# DEPARTMENT OF PLANNING & INFRASTRUCTURE

## **SUBJECT: MODIFICATION TO THE PROJECT APPROVAL FOR THE REDEVELOPMENT OF SYDNEY SHOWGROUND MAIN ARENA AT SYDNEY OLYMPIC PARK (MP10 0145 MOD 1)**

To determine a modification request for design changes to the redevelopment of the Sydney Showground Main Arena at Sydney Olympic Park.

NW Stand Sections

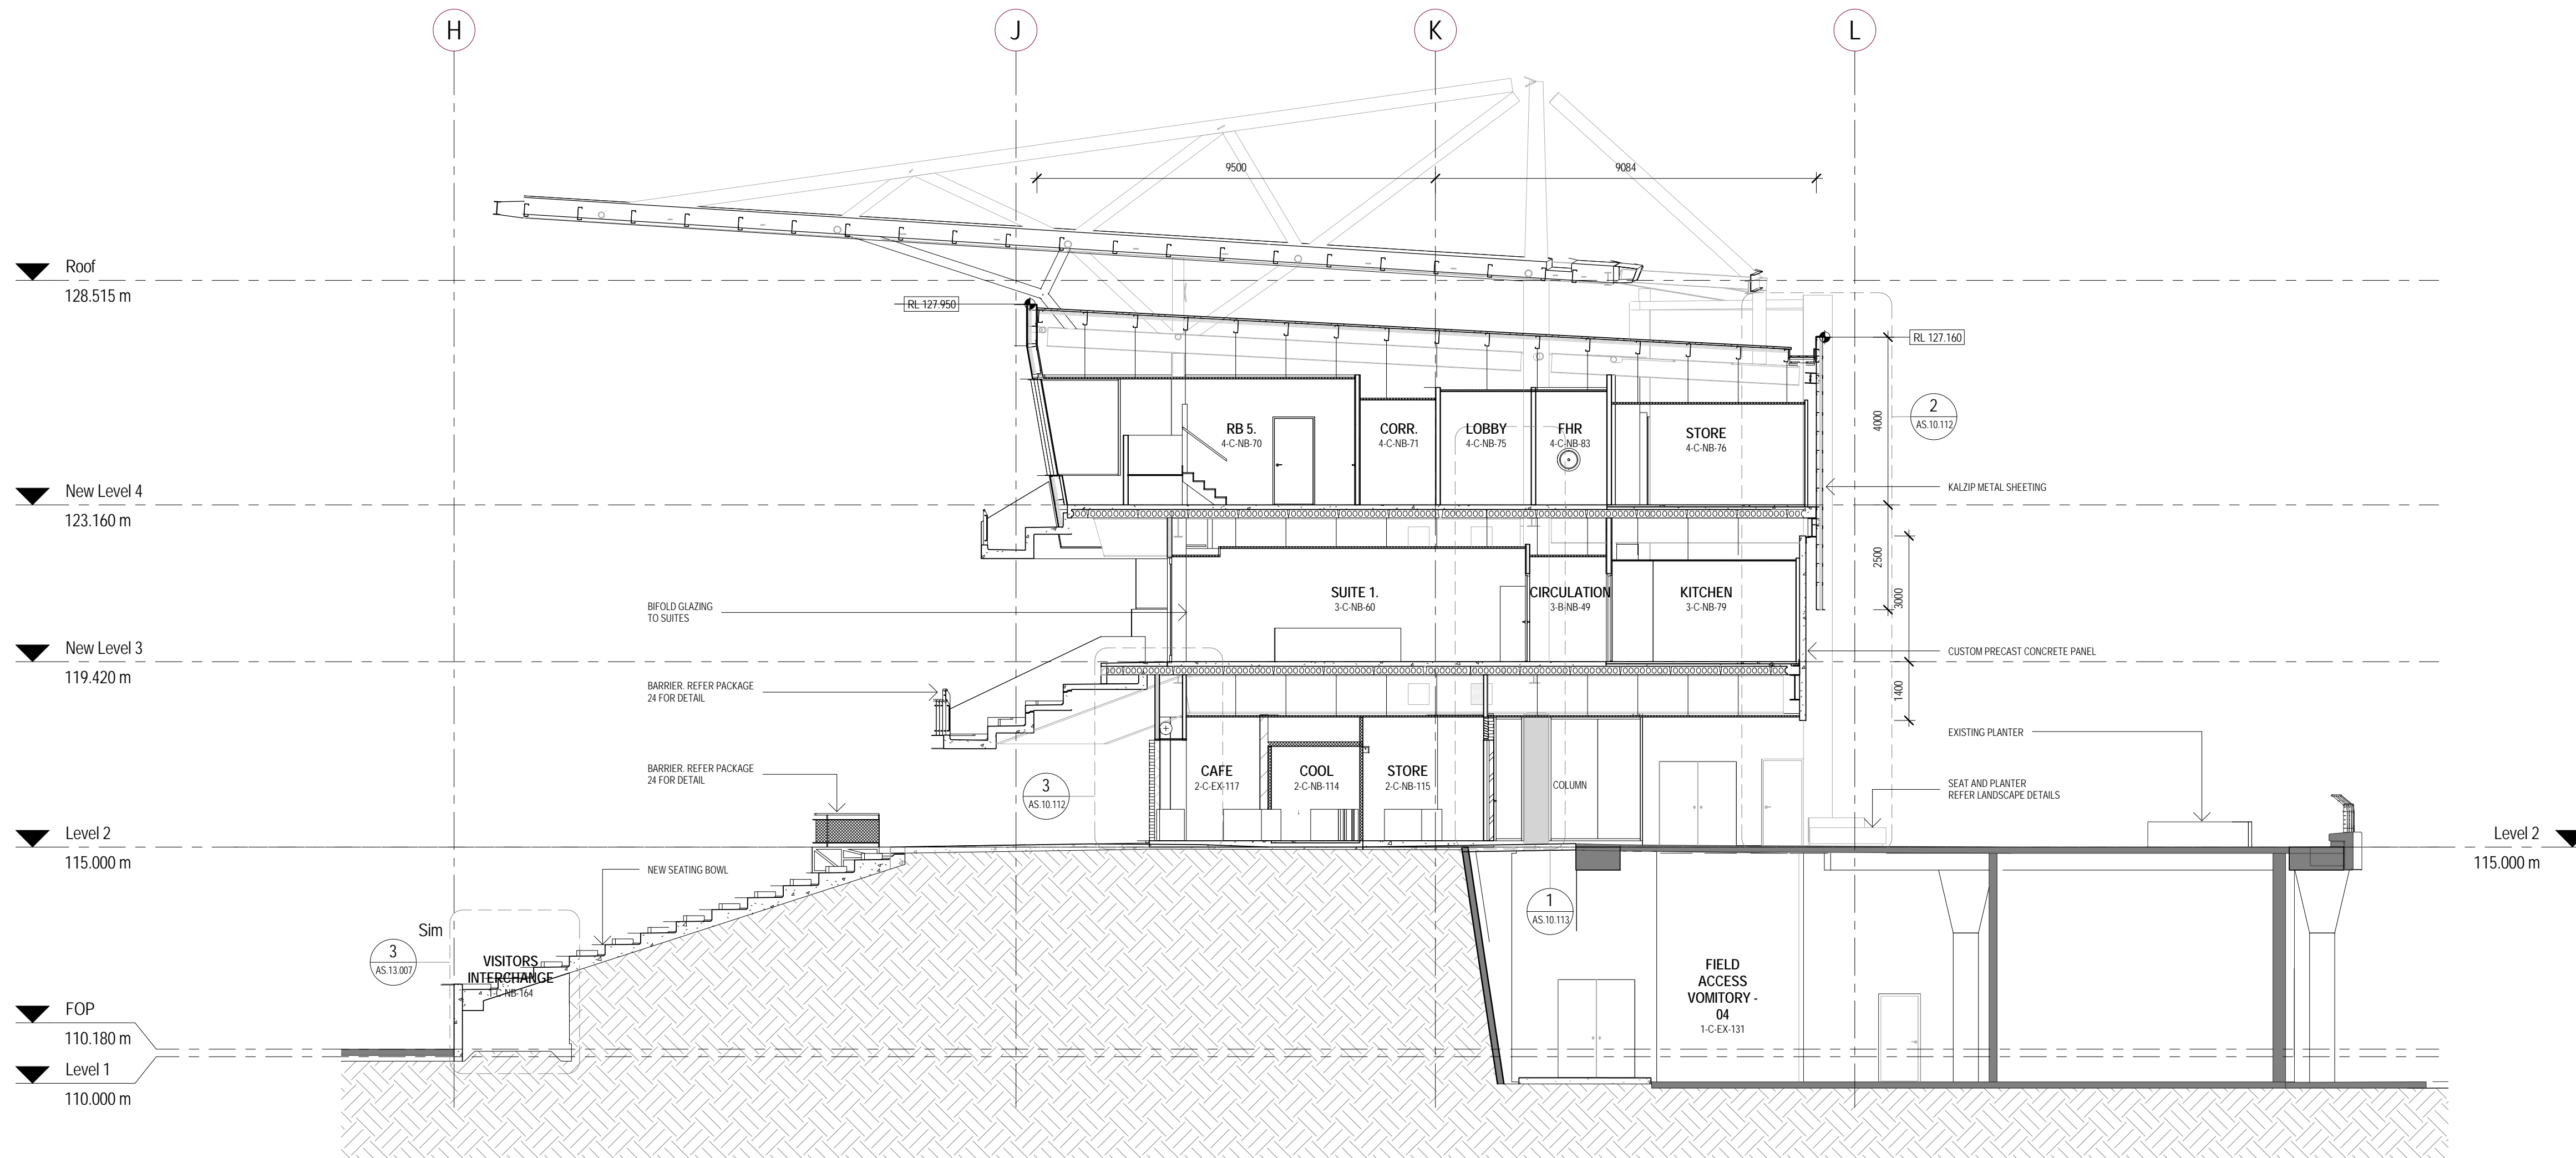
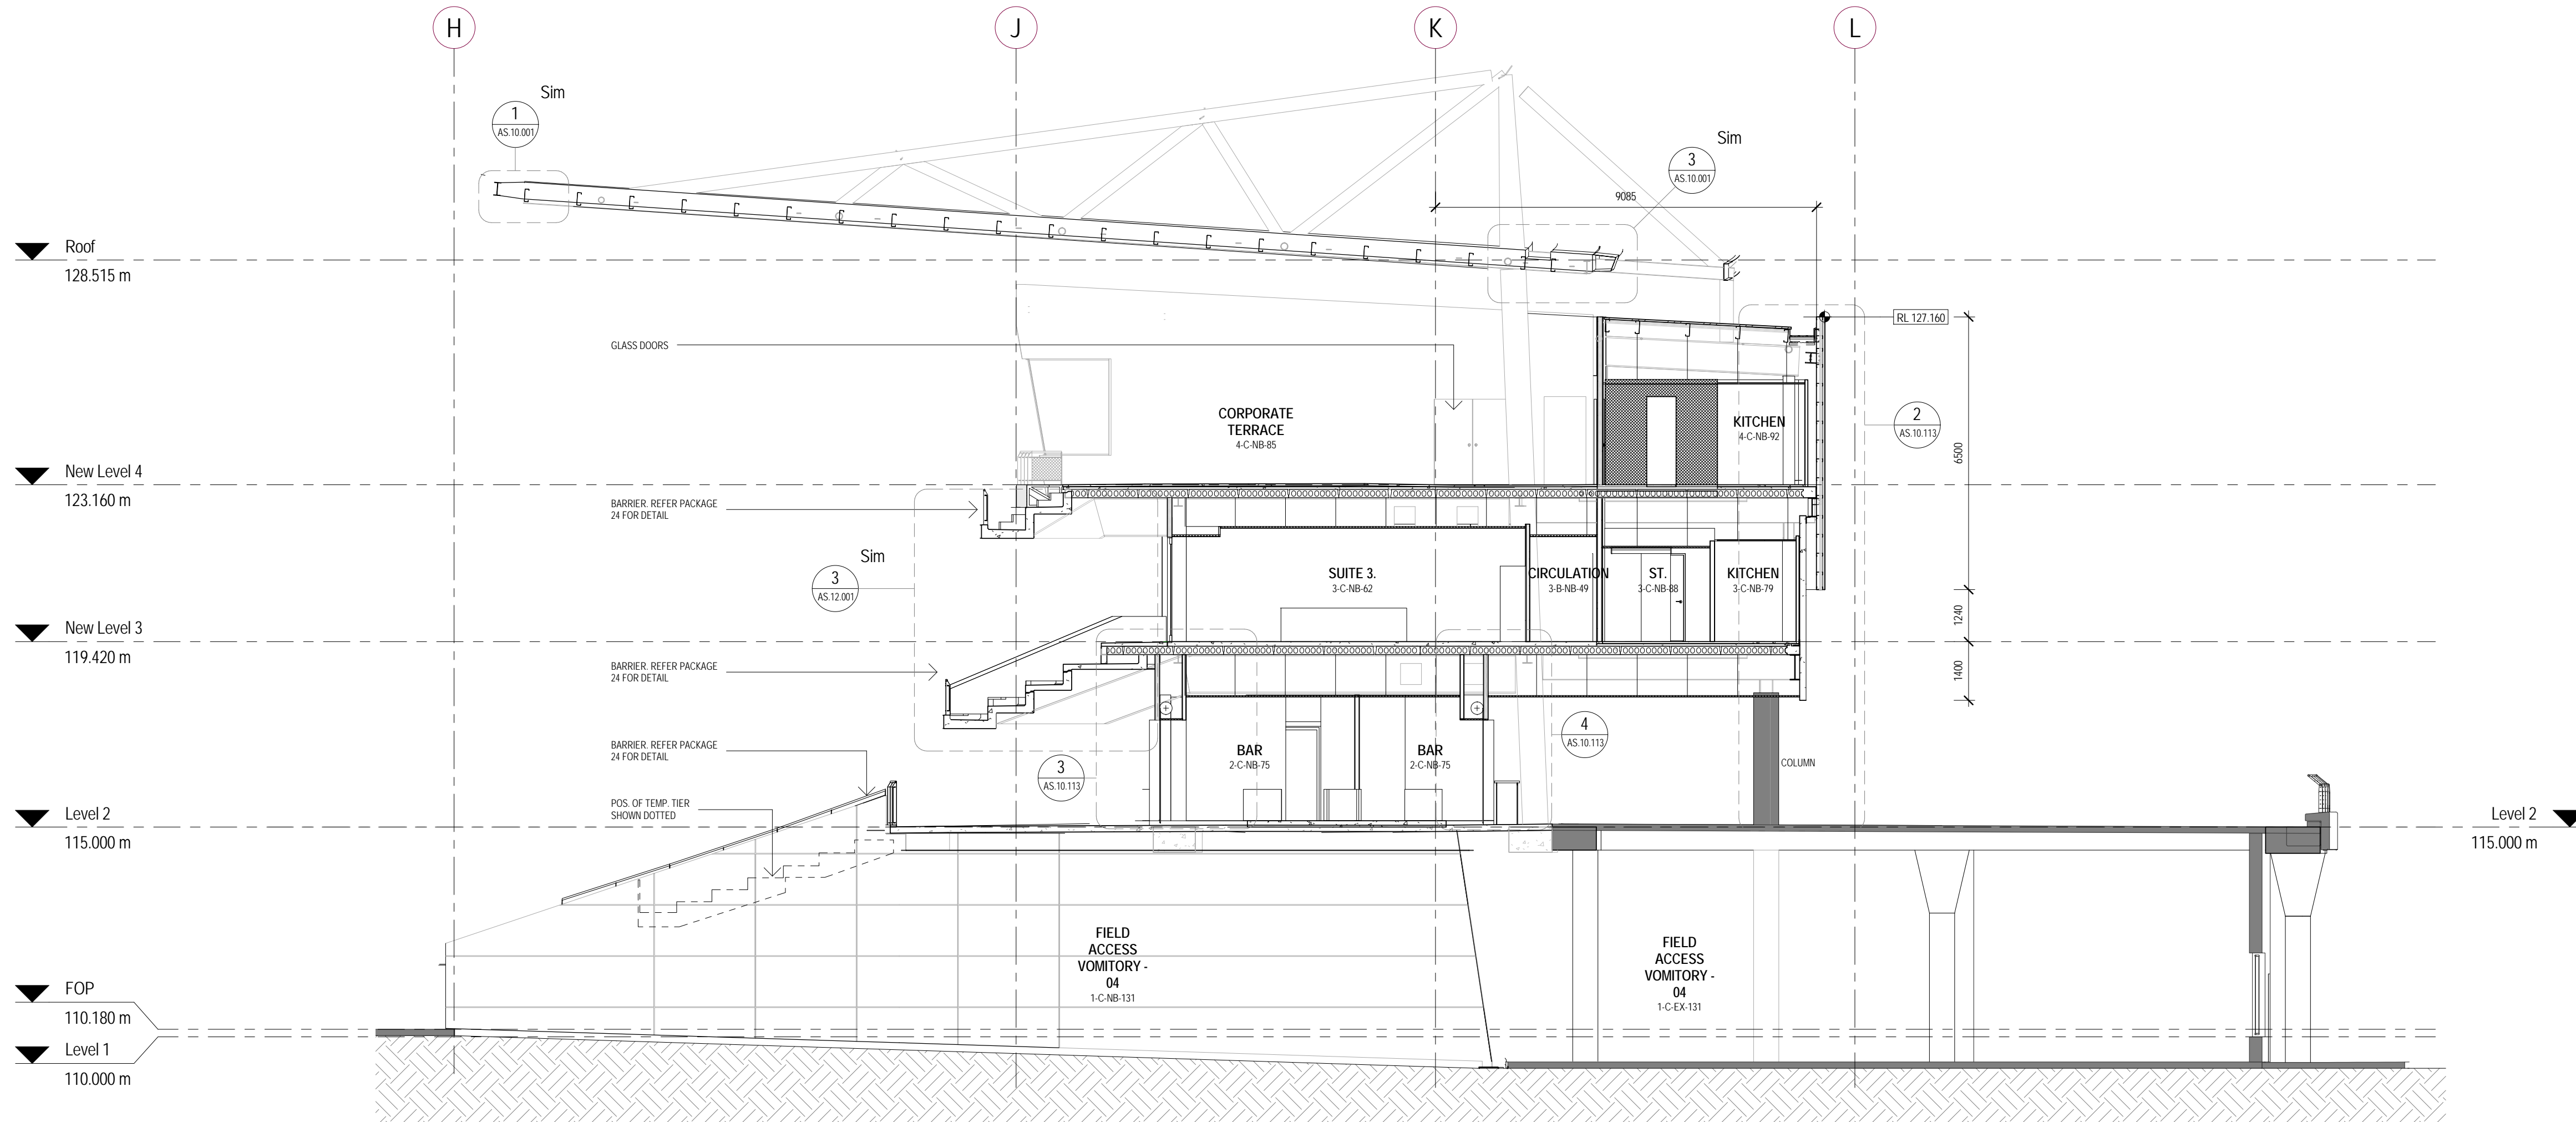
- the increased depth of the north-west stand and potential impacts on circulation should be clarified
- further details required regarding the operation of the temporary food court area, including demonstrating that it would not adversely impact pedestrian circulation.

- the extent of the increase to the north west was shown incorrectly on the plans and has since been rectified
- provided further details regarding the use of the temporary food court area.

Stage 1a - Level 3

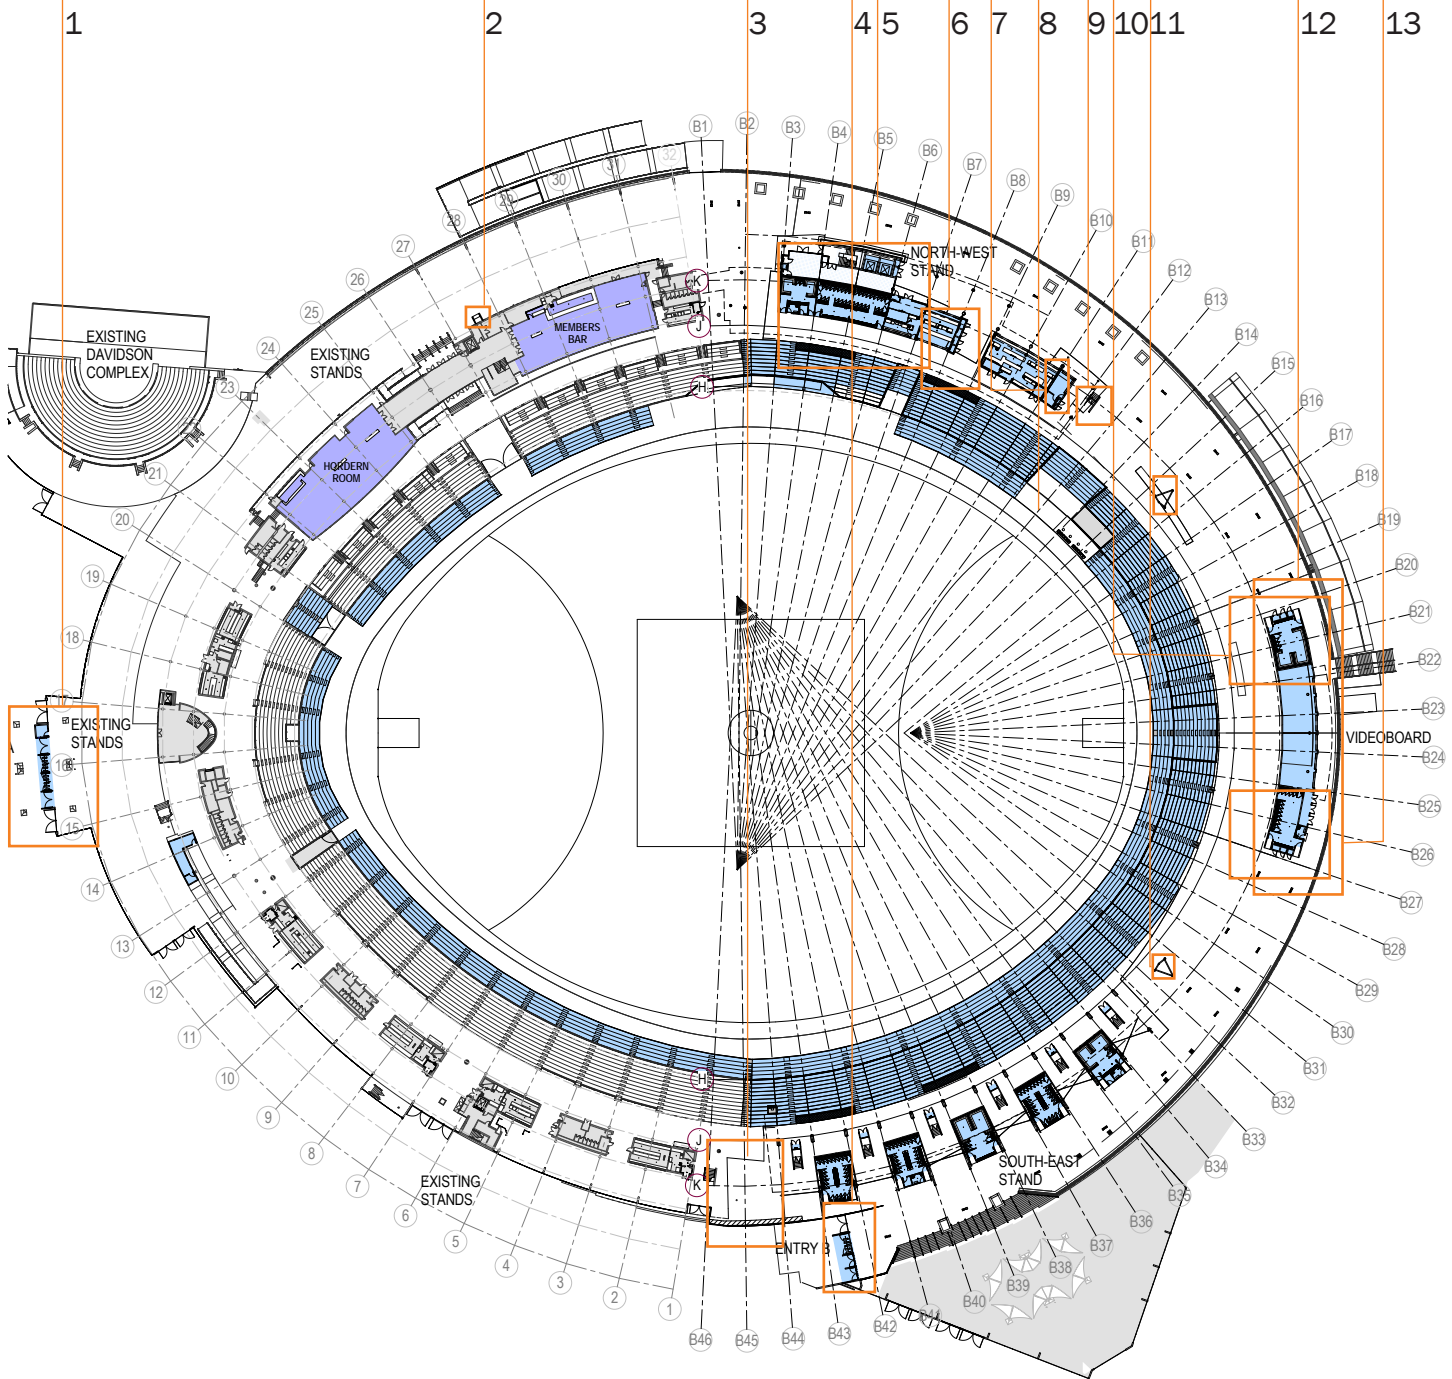
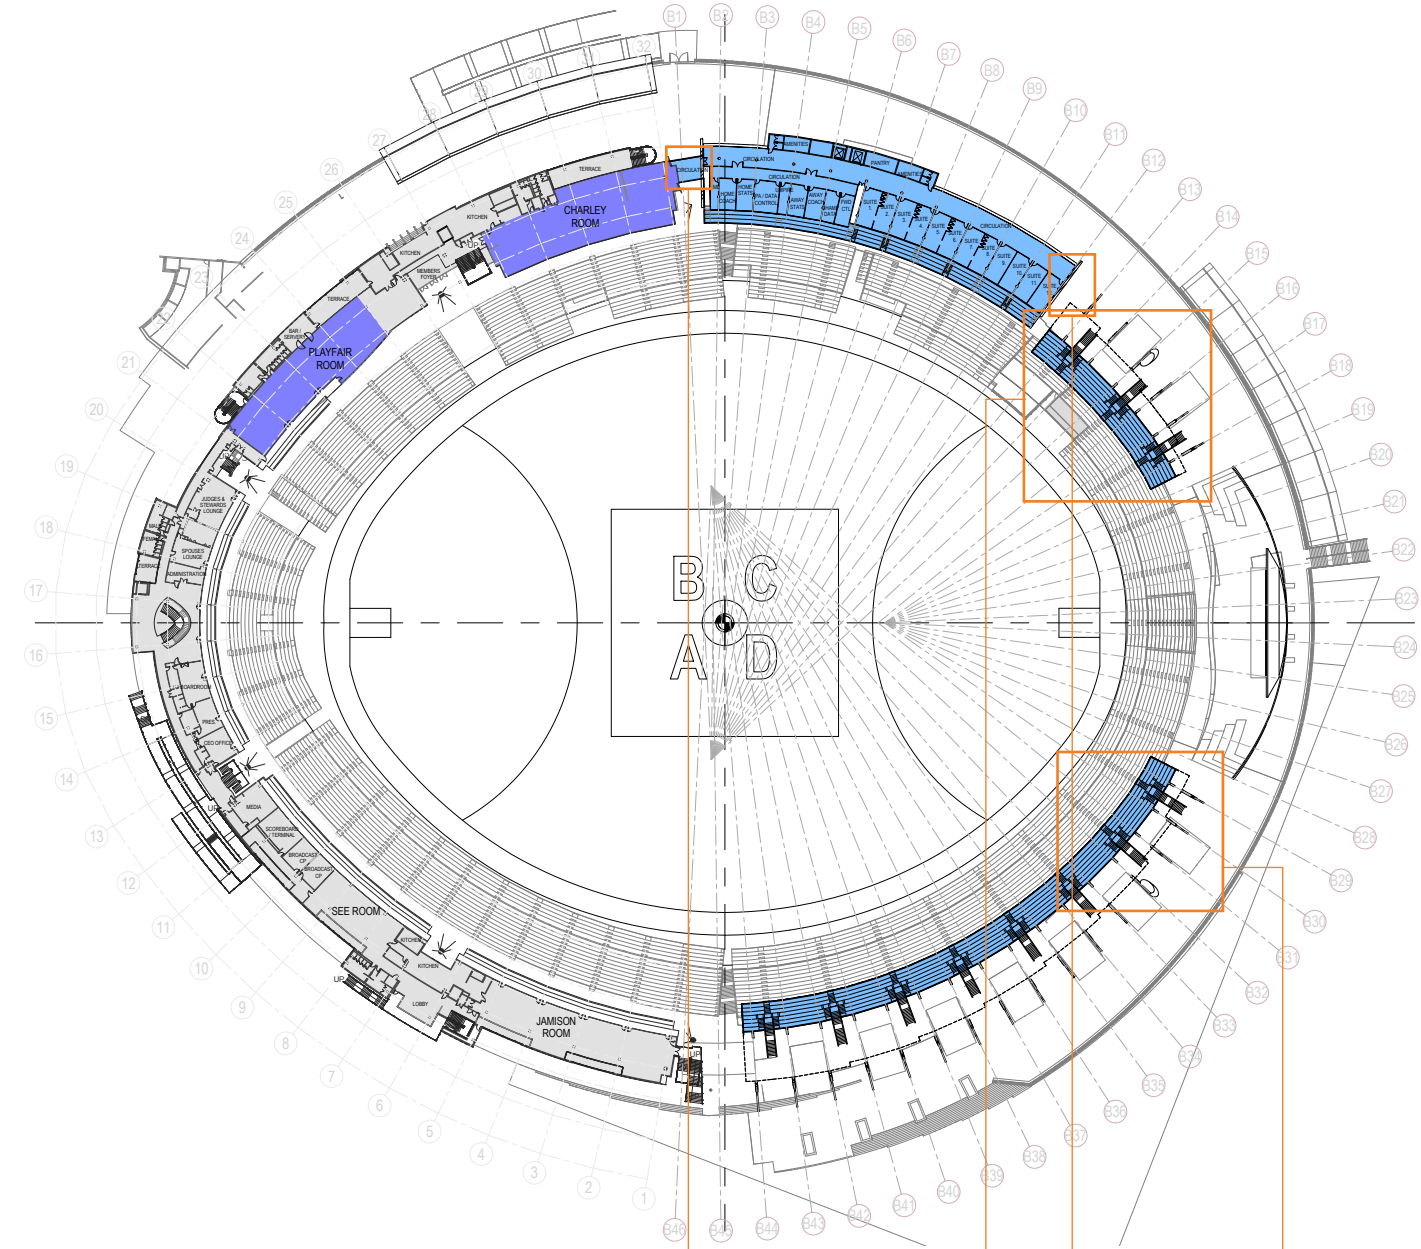
- design changes may affect the operability of the existing building including restricting access and should be verified
- clarification required regarding the total number of seats delivered in Stage 1a

- clarified the total number of seats for Stage 1a and Stage 2, with minor increase to the maximum capacity after Stage 2 (for the 'Sporting Mode') of seven spectators (total 25,007 persons)
